**Consultation Response from Mike Hibbert,
KC Waste Strategy(Refuse & Recycling)**

2023/91344 Land adj, 21, Thomas Street, Lindley, Huddersfield, HD3 3JJ

Outline application for erection of care home (Use Class C2) of up to 60 beds with associated access and sub station

Responding Ref: WPS 23-032

Drawing Title
Proposed Site Plan

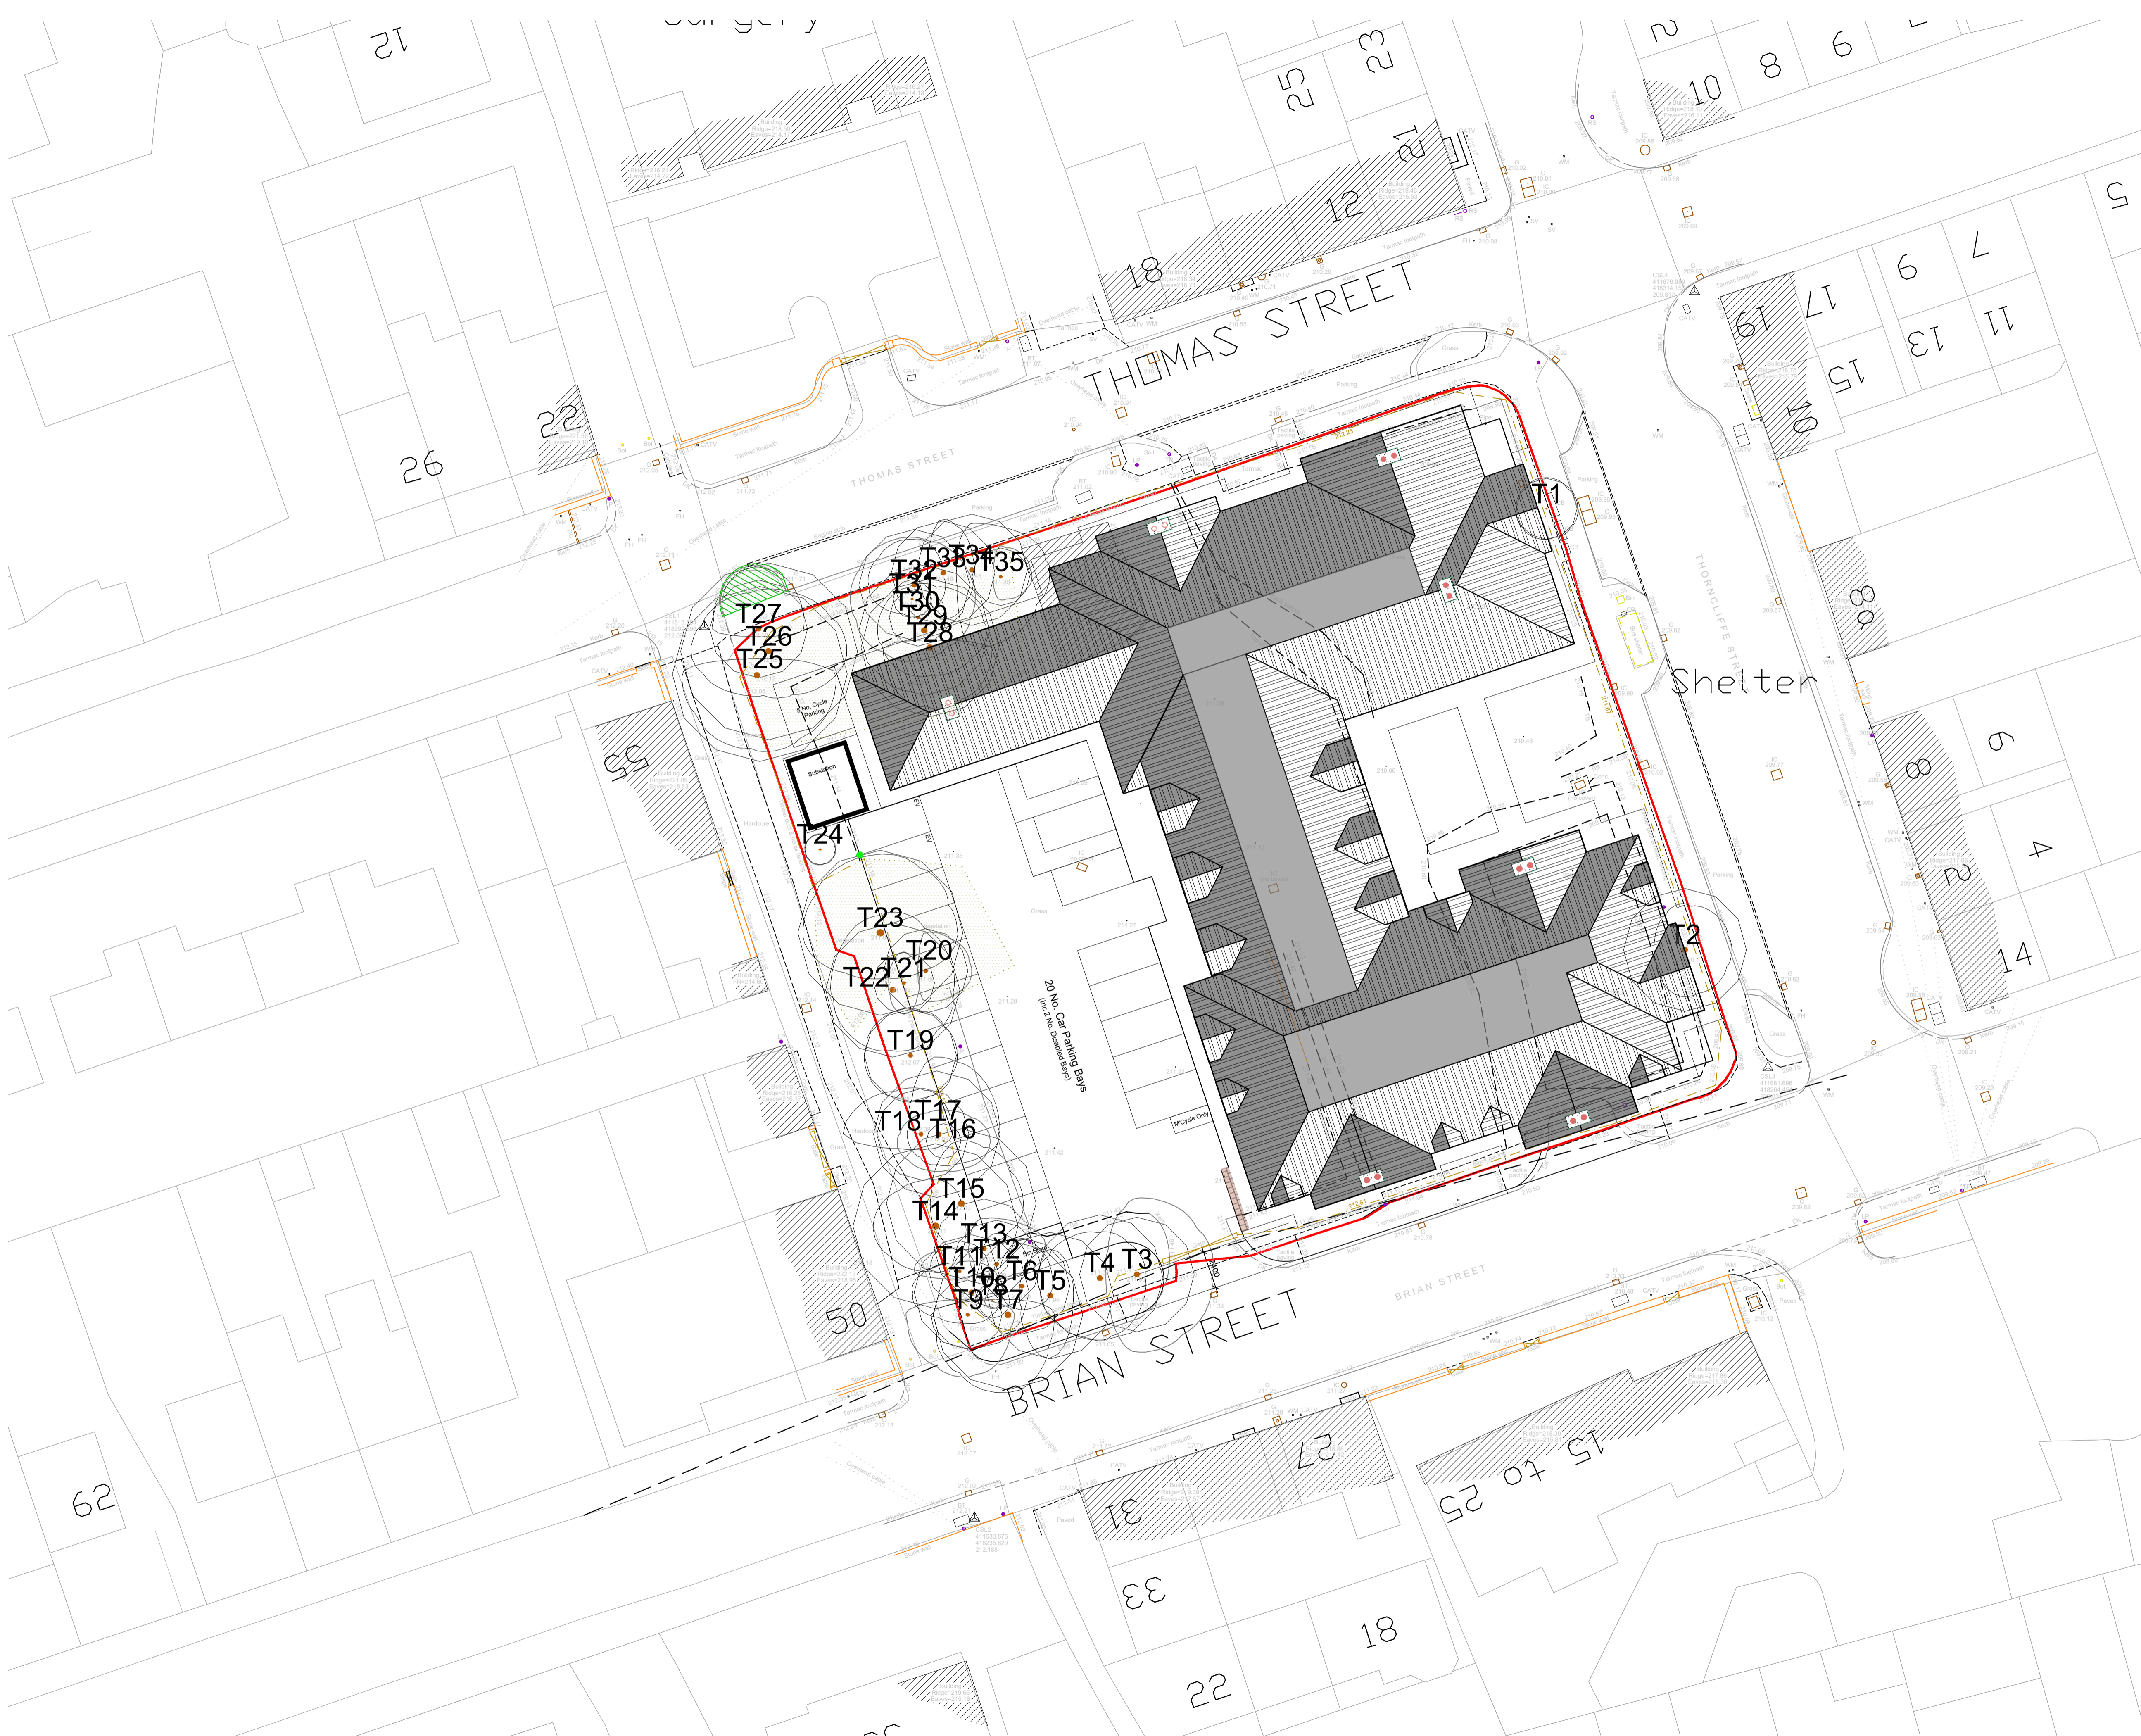
The Proposed Site Plan (9-2 Rev Q) dated 5/5/23 shows the location of a bin store near site entrance in the southwest corner of the site, which is accessible via Brian Street.

- The amended location of the bin store and access arrangements are welcomed.
- For a 60-apartment development the required waste storage capacity, discounting any waste generated from the communal areas and kitchen, should be approximately 4200ltrs (70ltrs x 60) for both residual and recycling containers. The bin store identified on the plan therefore must be sufficient to accommodate 8 X1100ltrs wheeliebins.

- Guidance indicated the floor space for 1100ltr wheeliebins is 1575mmx1190mm with space to manoeuvre the bins within the store, so the bin store dimensions should reflect the number of bins and will depend on configuration within the store.

- The bins should be contained within a purpose designed store. Details of bin store construction requirements including screening can be found in the Kirklees Waste Management Design Guide 2020. The bin store should be secure to prevent theft, unauthorised use/ fly tipping, arson or rough sleeping. If the store has gates these must be wide enough to enable passage through with a wheeliebin.

- Bin store surfaces should be durable and waterproof enough to withstand heavy duty cleaning such as power washing. The storage area needs to have suitable drainage.

- The drag out distance for wheeliebins from a Bin store/ premises to the collection vehicle is under 15m that is acceptable.
- The bin storage area and access routes to the Bin Collection Point (BCP) should be constructed to withstand point loading and movement, impacts of larger bins over time, and to resist future rutting, pitting, cracking, or other such surface degradation that would impair bin manoeuvring. There should not be a step between the floor level of the store and car park level. Active measures should be taken to avoid cars parking in front of the doors to the waste store.
